Elm Terrace  
Addendum 04  
September 28, 2011

Issued by: Mitchell & Associates

RE: Clarification on concrete paver types and colors.

Sheet No: 9

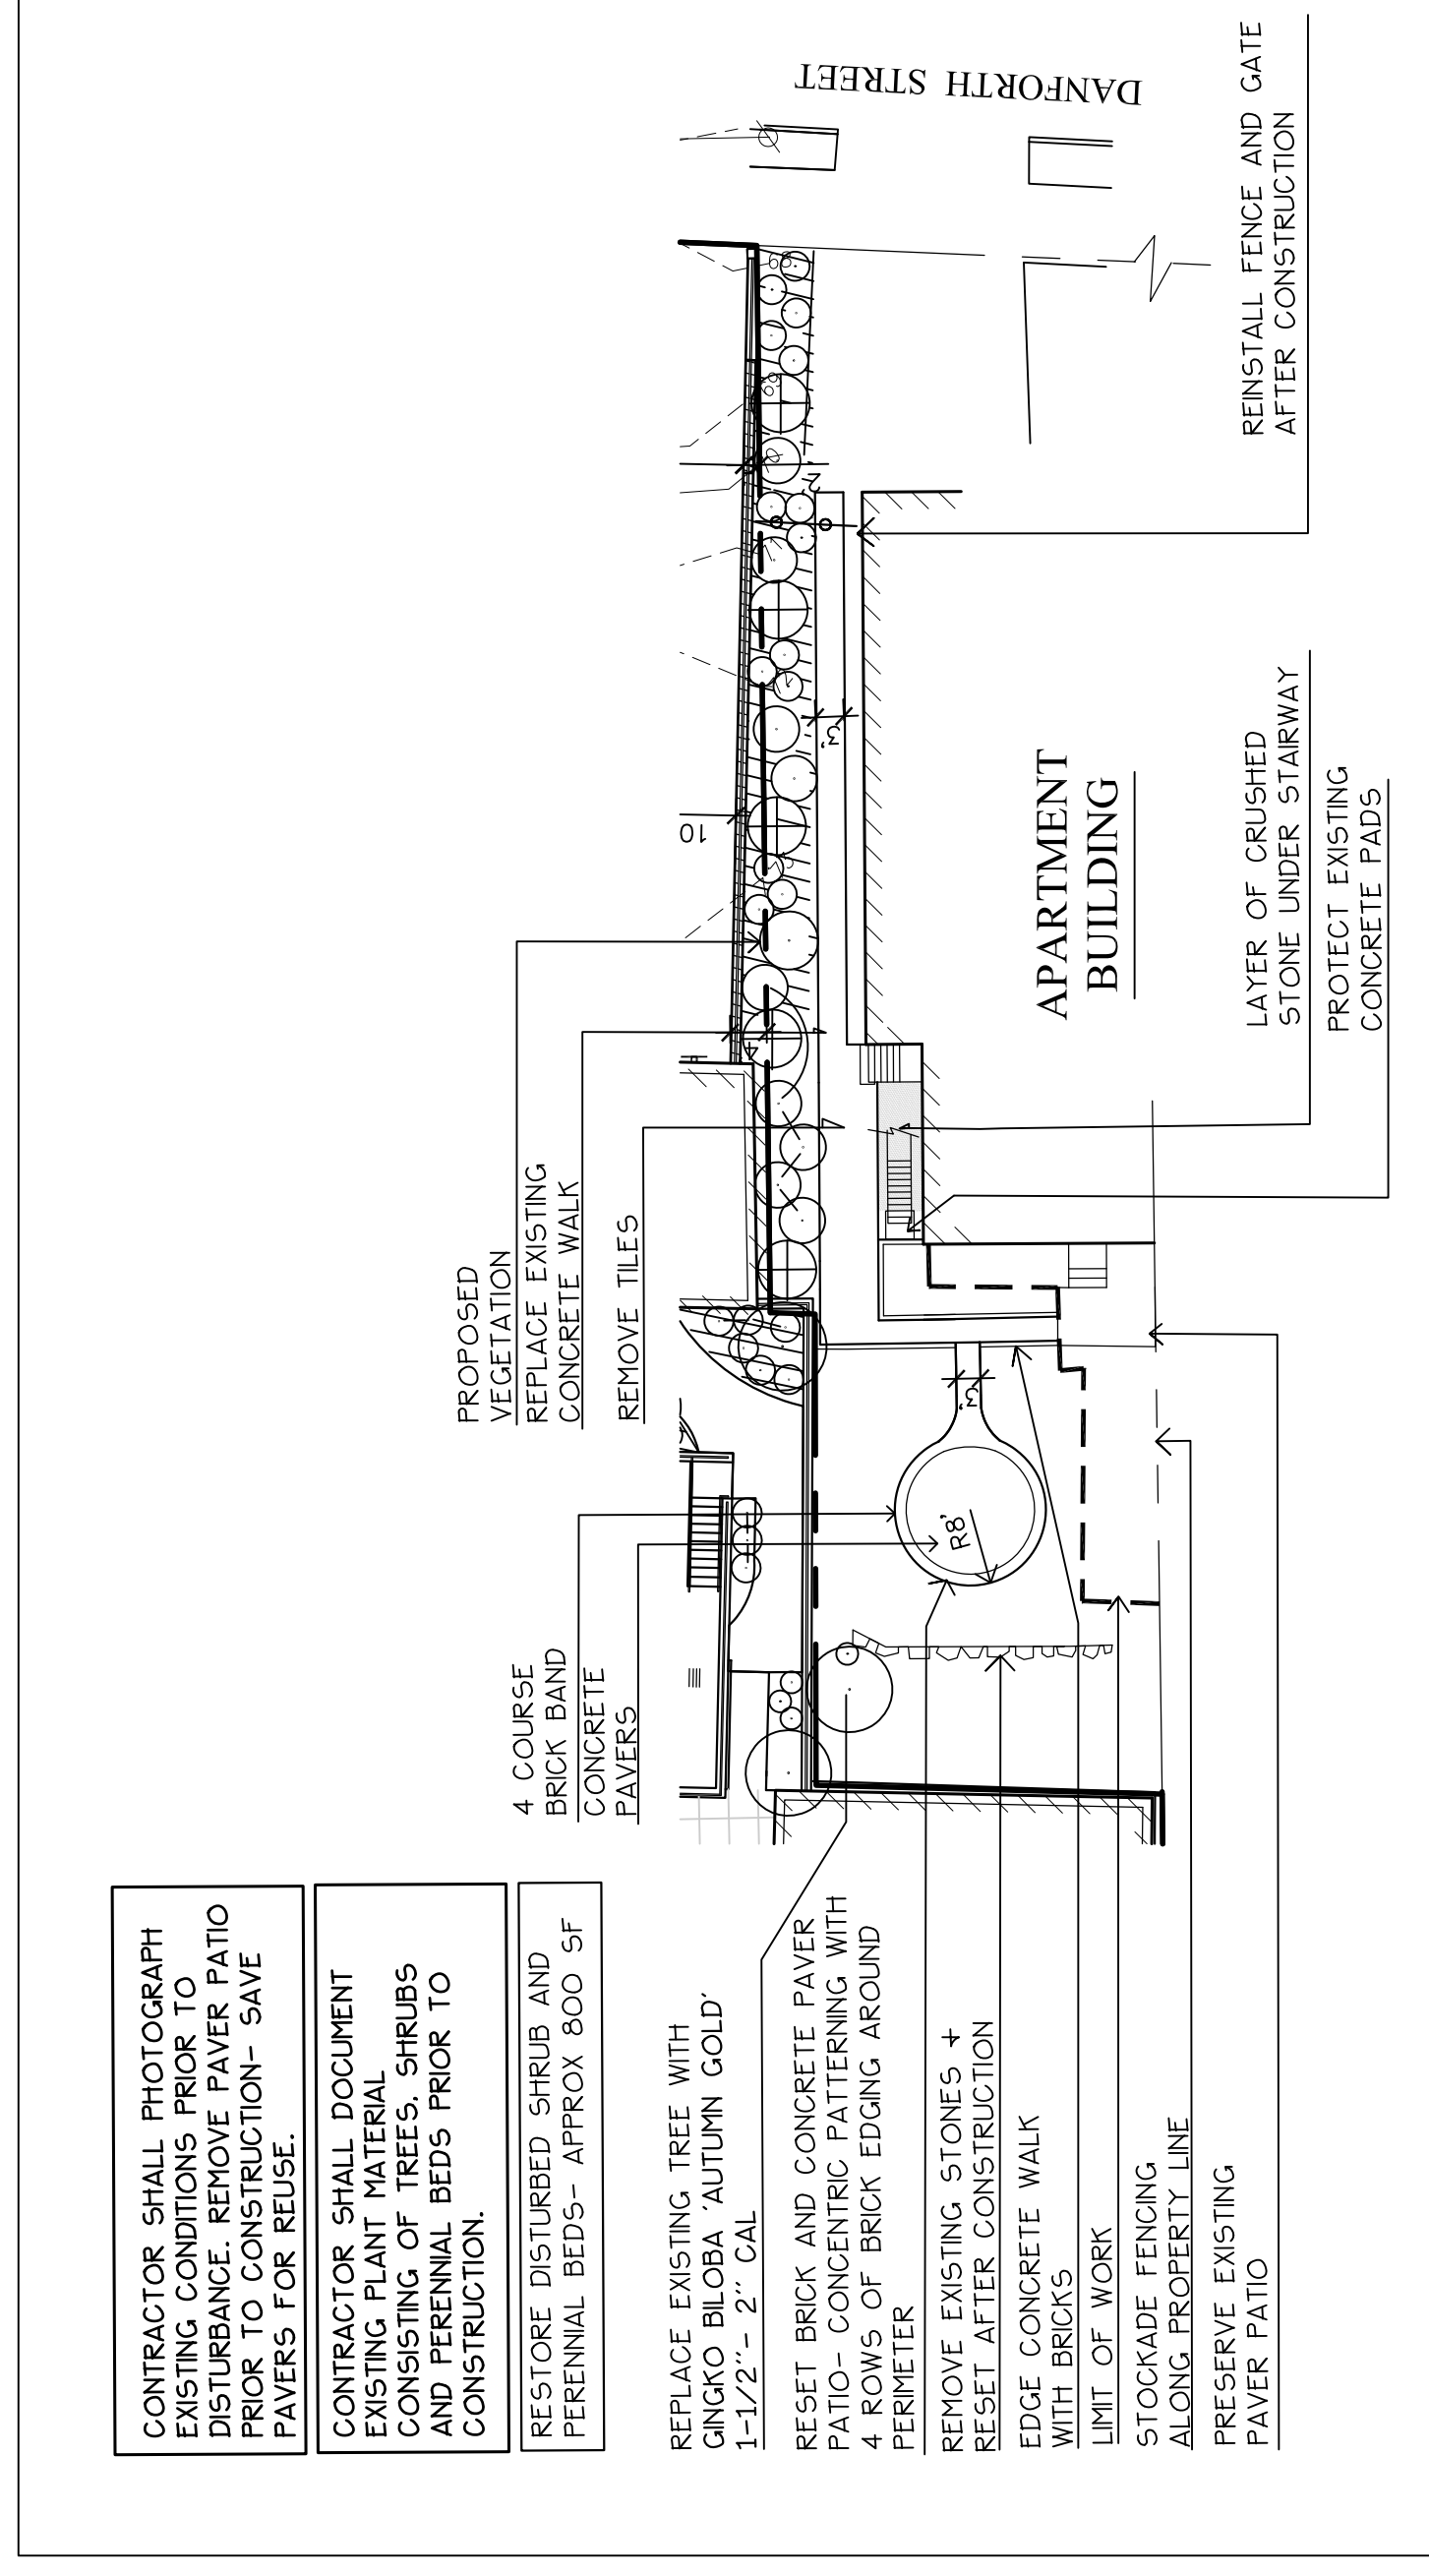
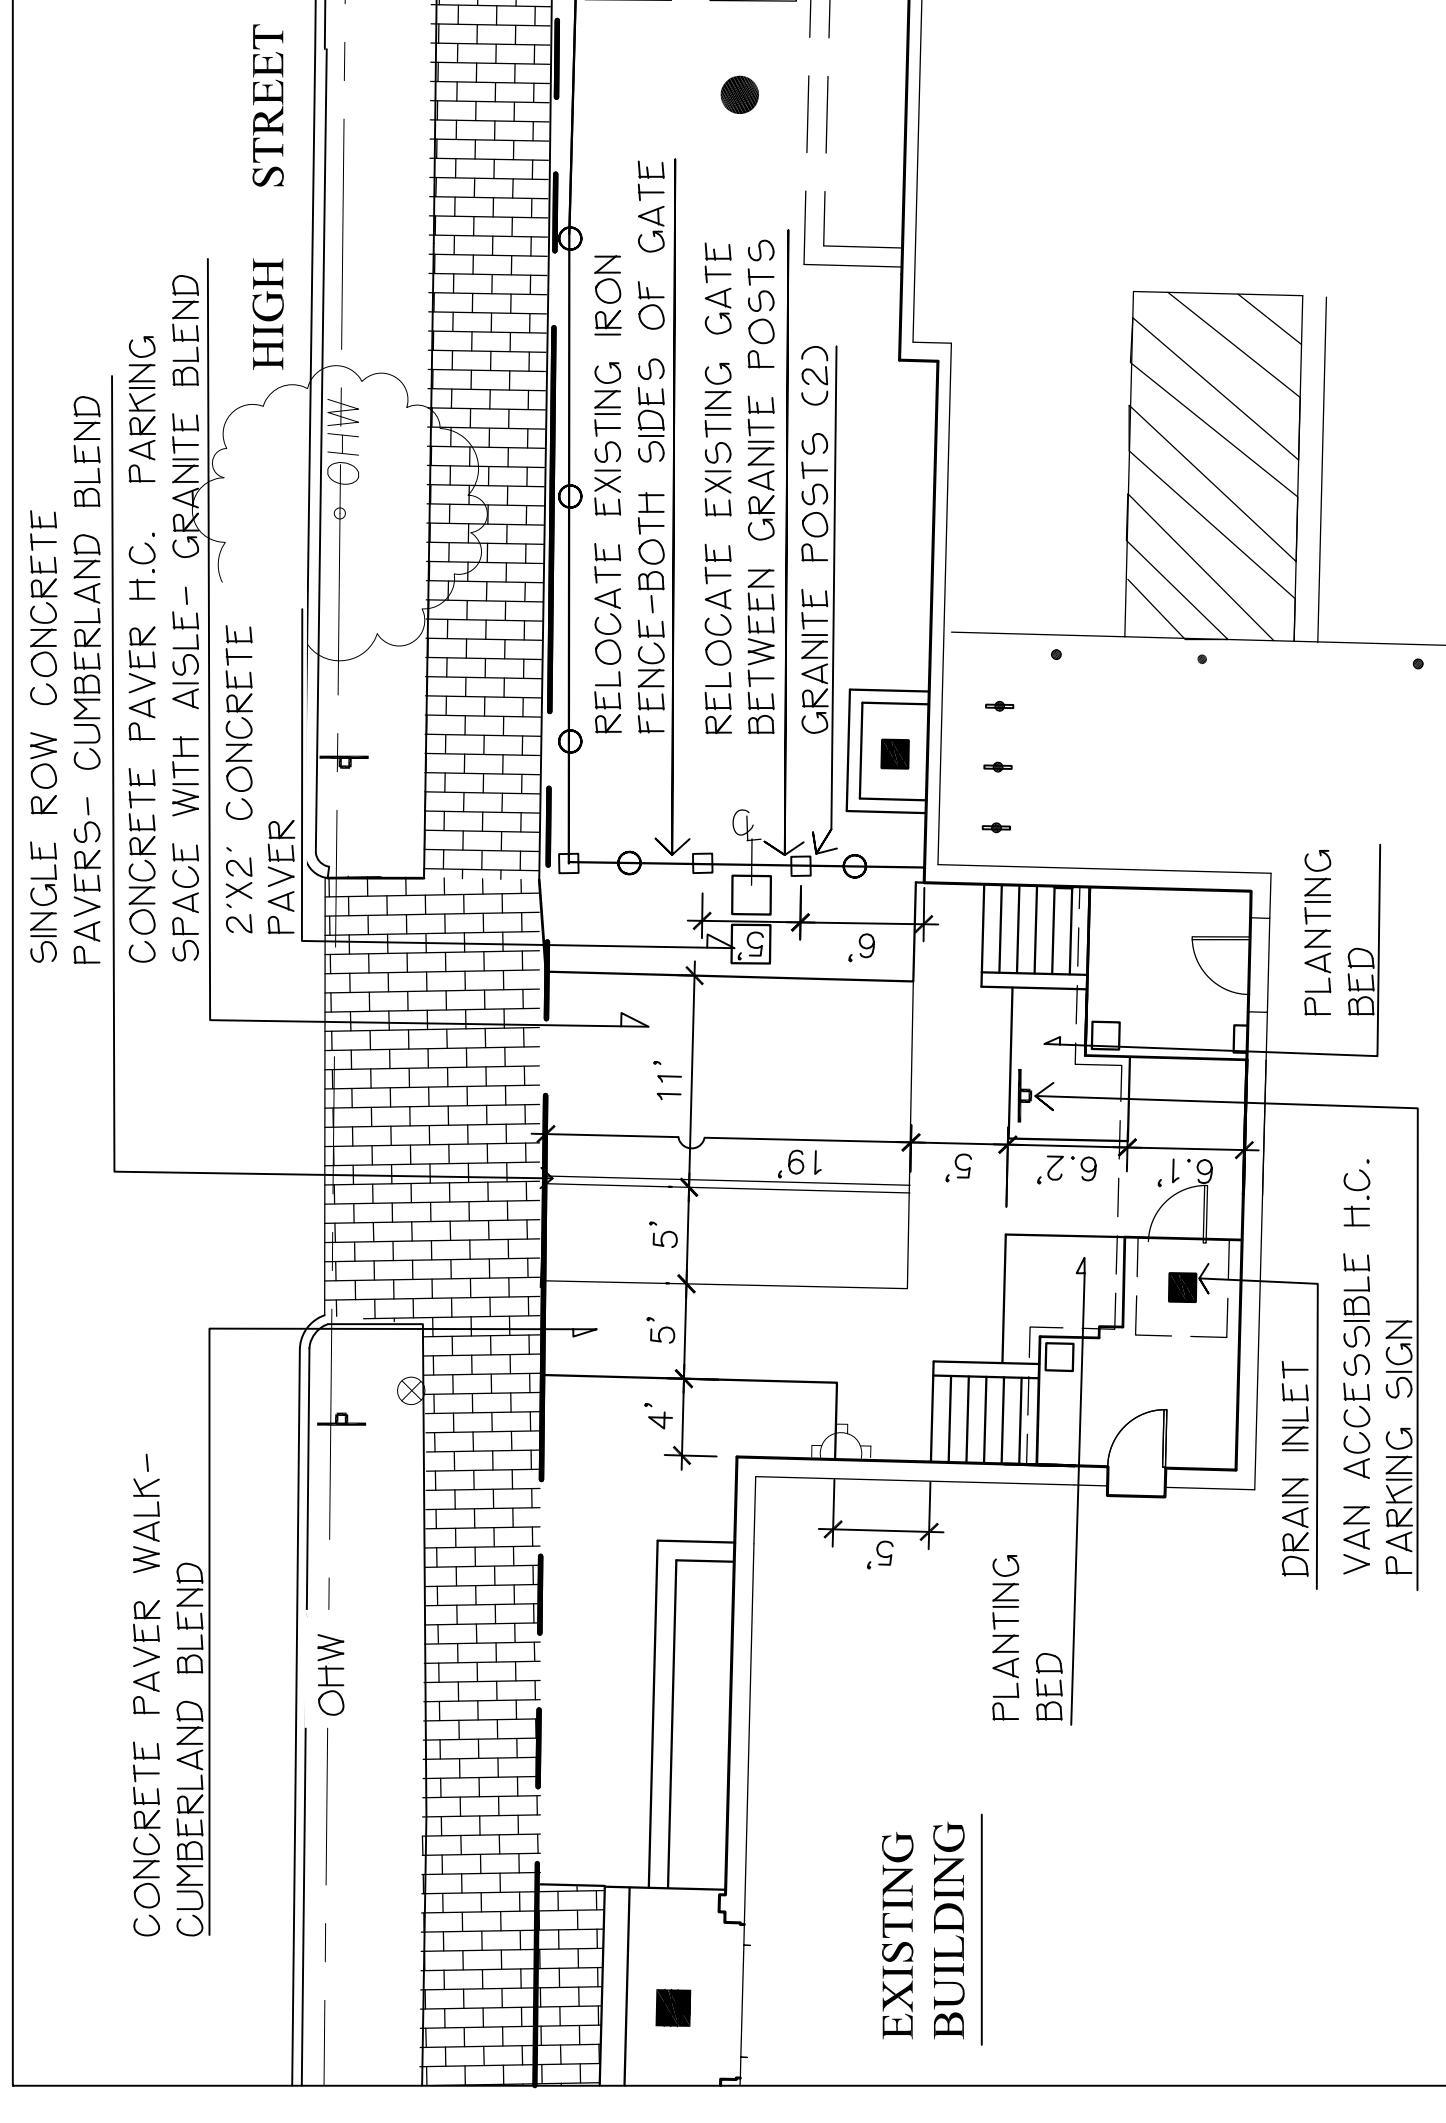
All other concrete pavers shall be:

Type: Holland Stone

Color: as noted on Sheet 9
